# CITY OF ALBUQUERQUE

**Re: Nusenda Credit Union**  
**2801 Juan Tabo Blvd. NE**  
**Traffic Circulation Layout**  
Architect's Stamp 07-06-22 (H21-D020)

Based upon the information provided in your submittal received 07-07-22, the above referenced plan cannot be approved for Building Permit until the following comments are addressed:

1 site plan
A001 1"=20'

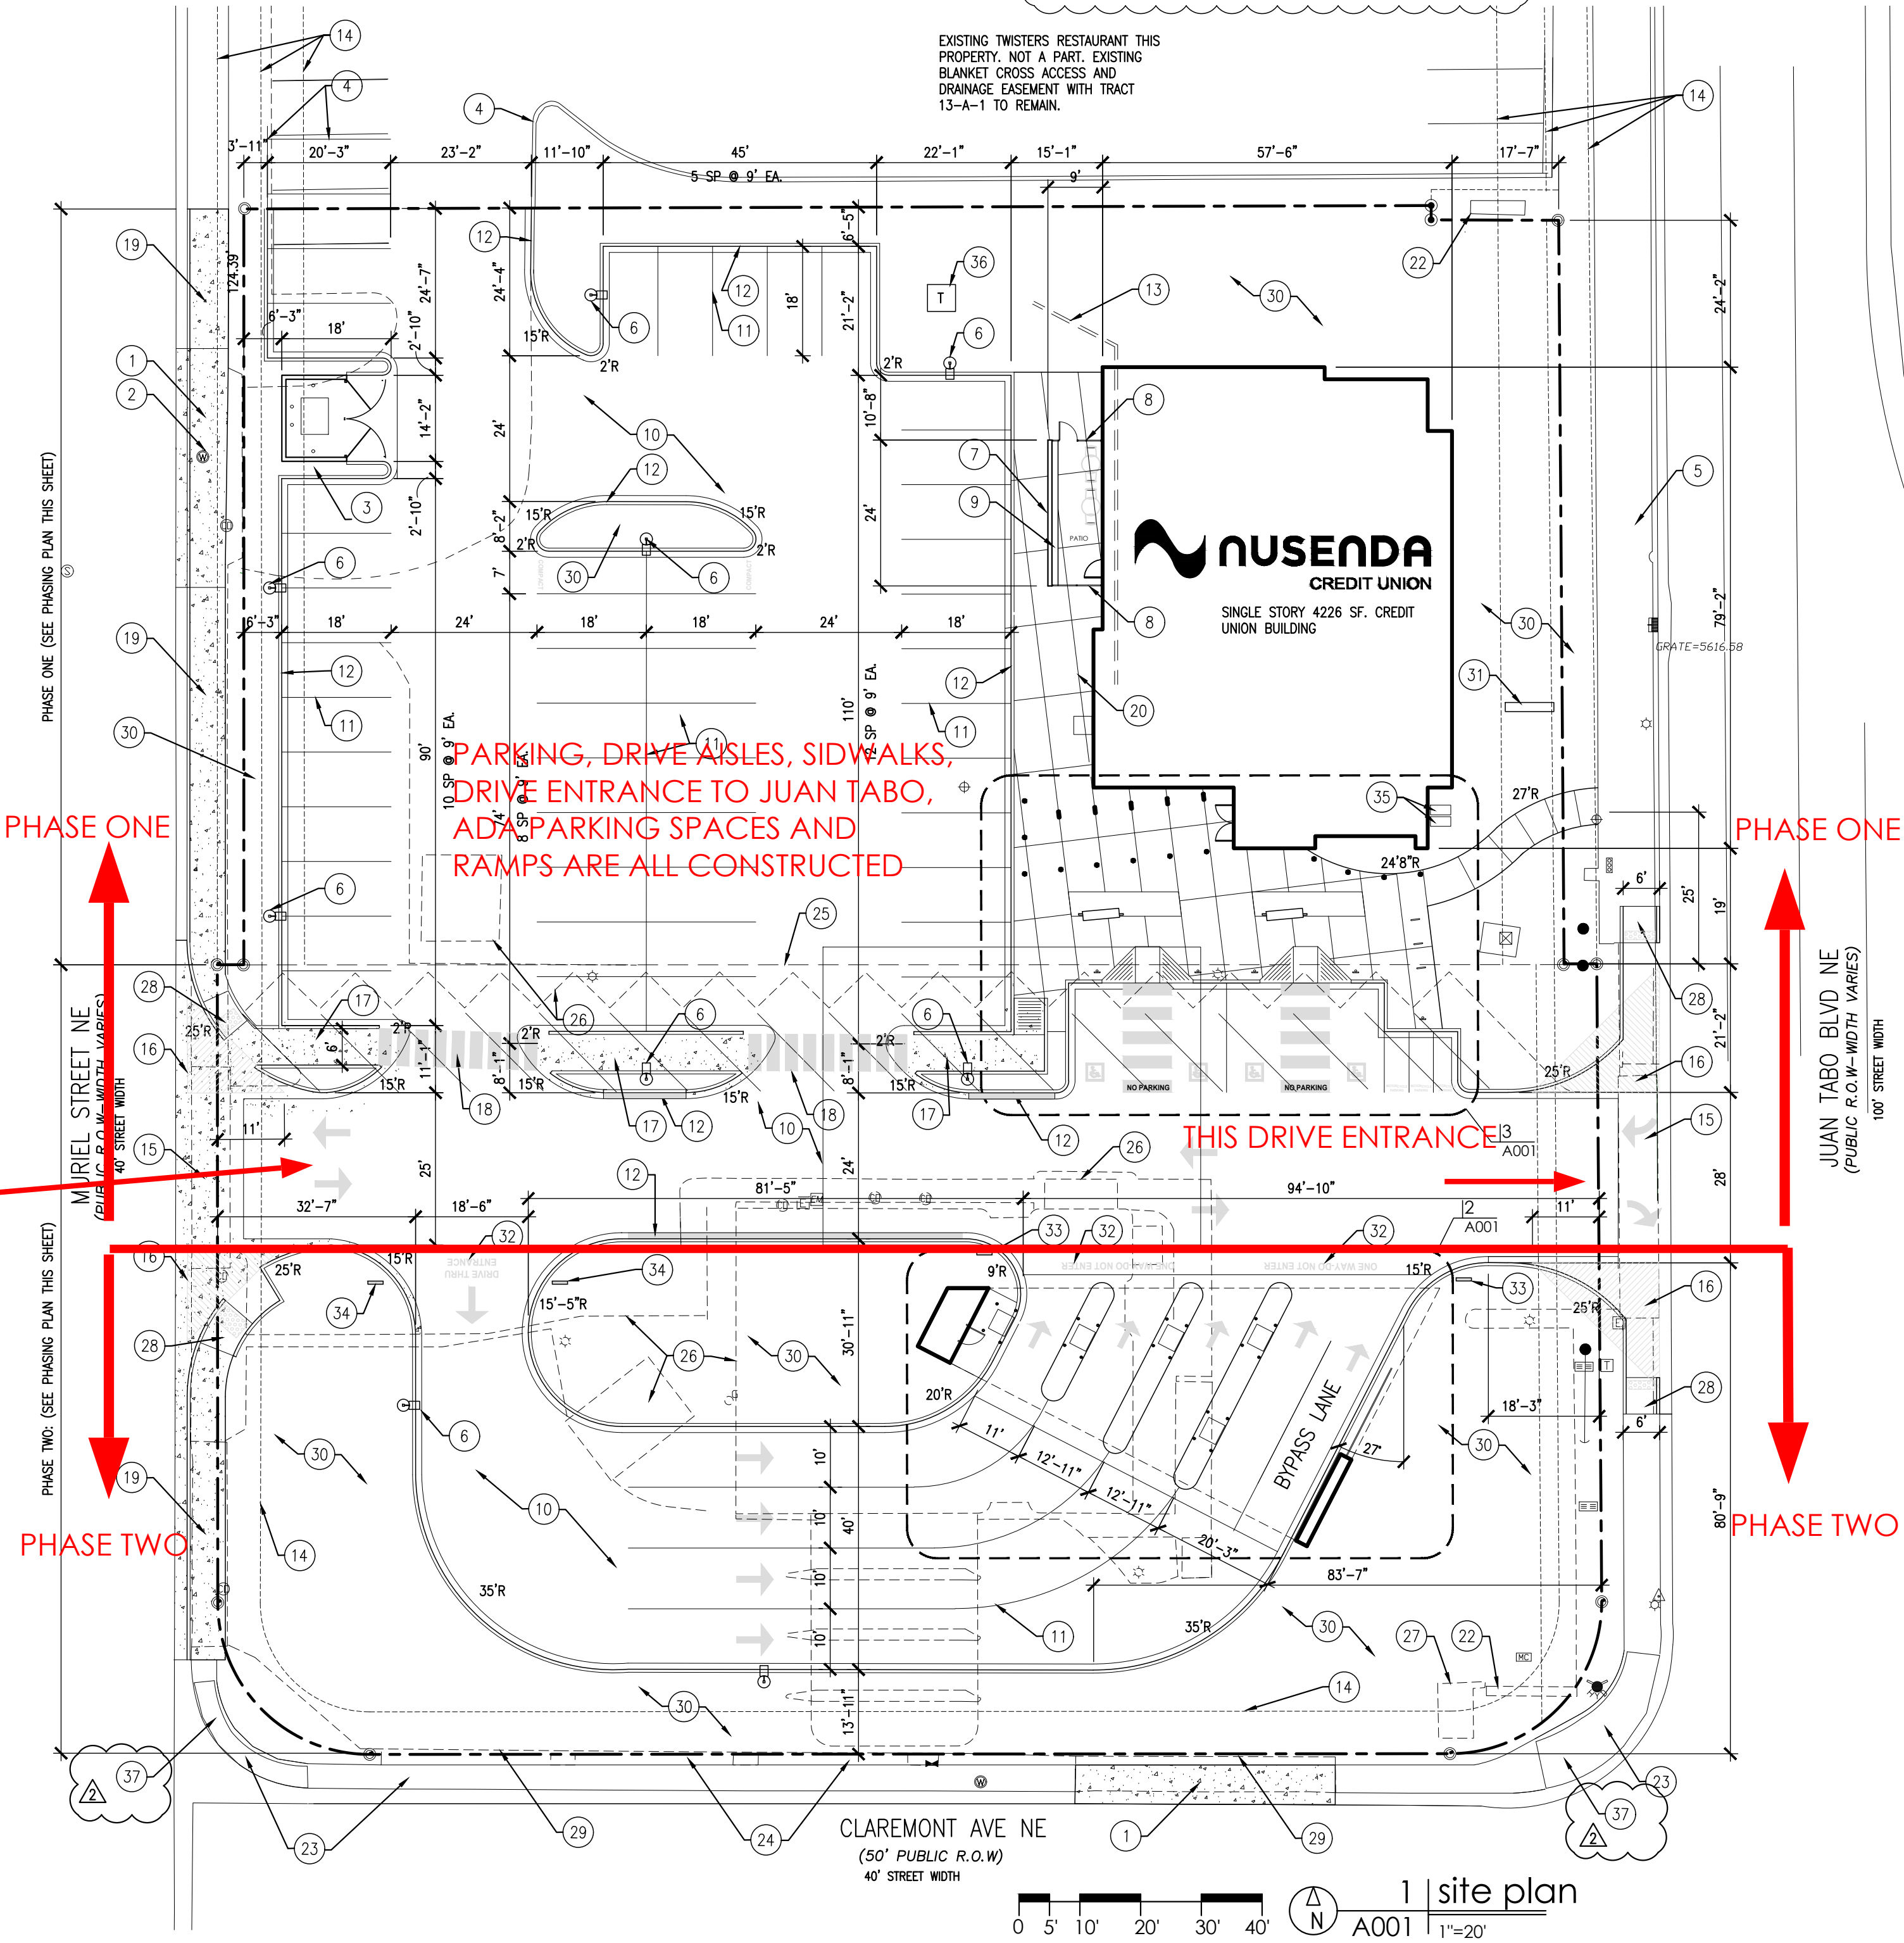
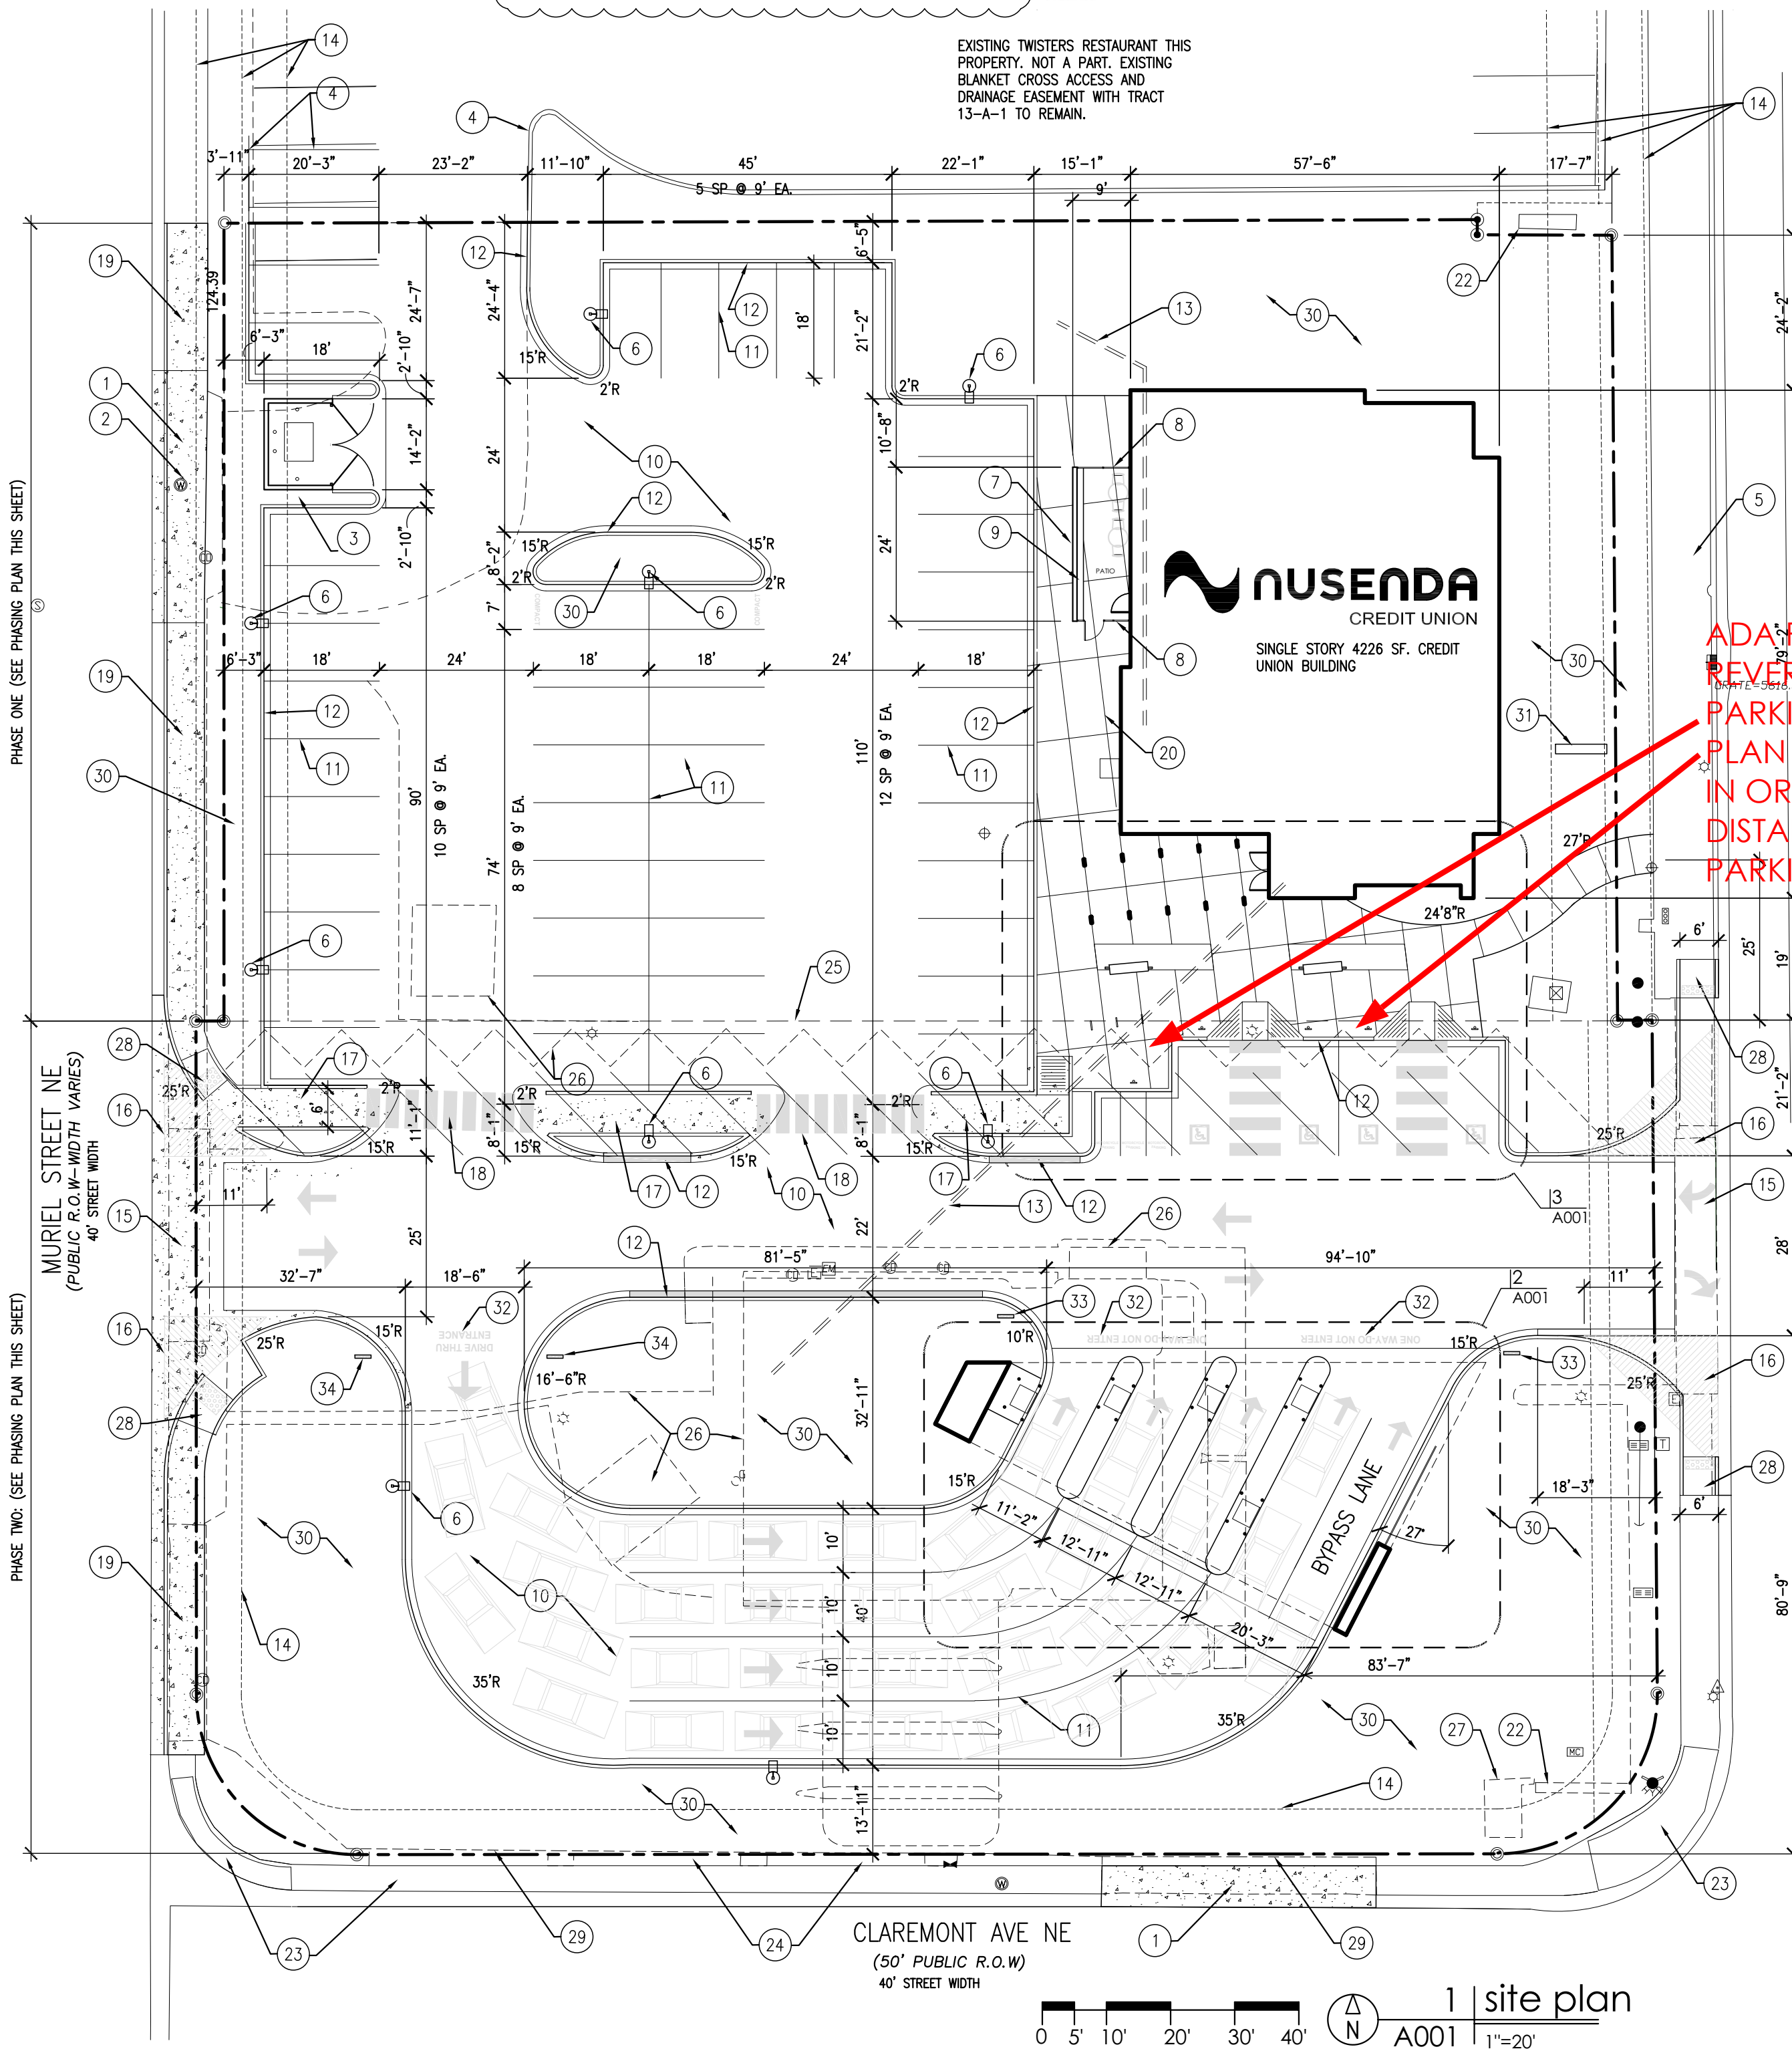
1. List the number of parking spaces required by the IDO as well as the proposed number of parking spaces including bicycle and motorcycle parking
2. Identify the right of way width, medians, curb cuts, and street widths on Juan Tabo Blvd. NE and Muriel St. NE

3. Driveway access off Juan Tabo and Muriel: ADA curb ramps and landing need to be located on the Public City Right Of Way.
4. Please provide details (slopes) for the proposed ADA ramps inside the property.

5. Sheet A002 is missing.
6. Keynote 1: reference COA std dwg 2430.
7. The ADA accessible parking sign must have the required language per 66-7-352.4C NMSA 1978 **"Violators Are Subject to a Fine and/or Towing."** Please call out detail and location of signs.

11. Bicycle parking spaces shall be at least 6 feet long and 2 feet wide.
12. Per the IDO, a 6 ft. wide ADA accessible pedestrian pathway is required from the public sidewalk to the building entrances. Please clearly show this pathway and provide details.

13. Per DPM, a 6 ft. wide ADA accessible pedestrian pathway is required from the ADA parking stall access aisles to the building entrances. Please clearly show this pathway and provide details.

14. ADA accessible pedestrian pathway should not be placed behind parking space or adjacent to a vehicular way. Vehicle and pedestrian/wheel chair conflicts should be avoided as much as possible.

15. All one-way drives shall have "One Way" and "Do Not Enter" signage and pavement markings. Please show detail and location of posted signs and striping.

16. The minimum drive through lane width is 12 feet with a 25 foot minimum radius (inside edge) for all turns. (A 15 foot radius can be used with an increase in lane width to 14 feet). Please dimension all lane widths and radii.

20. Add a note stating "All broken or cracked sidewalk must be replaced with sidewalk and curb & gutter." A build note must be provided referring to the appropriate City Standard drawing.
